From: Martyn White
Sent: 21 January 2019 17:08
To: Planning.Responses
Cc: Zac Denton
Subject: WA/89/18/L

WA/89/18/L

The application seeks retrospective consent for a replacement privacy screen. Whilst the description states a privacy screen' it is essentially an application for what appears to be metal fencing which has been painted a green colour. It is indicated that fencing panels replace previous panels.

Drawing / Elevation
of replacement
Privacy Screen
above existing
dwarf Wall

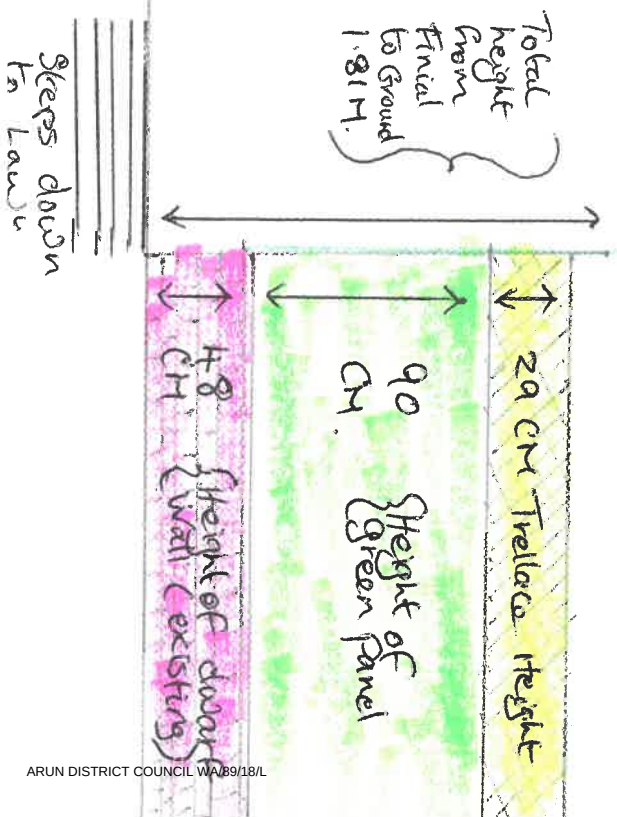
It is considered that the use of these panels within the grounds of the property is detrimental to the significance of the building, and cannot be supported.
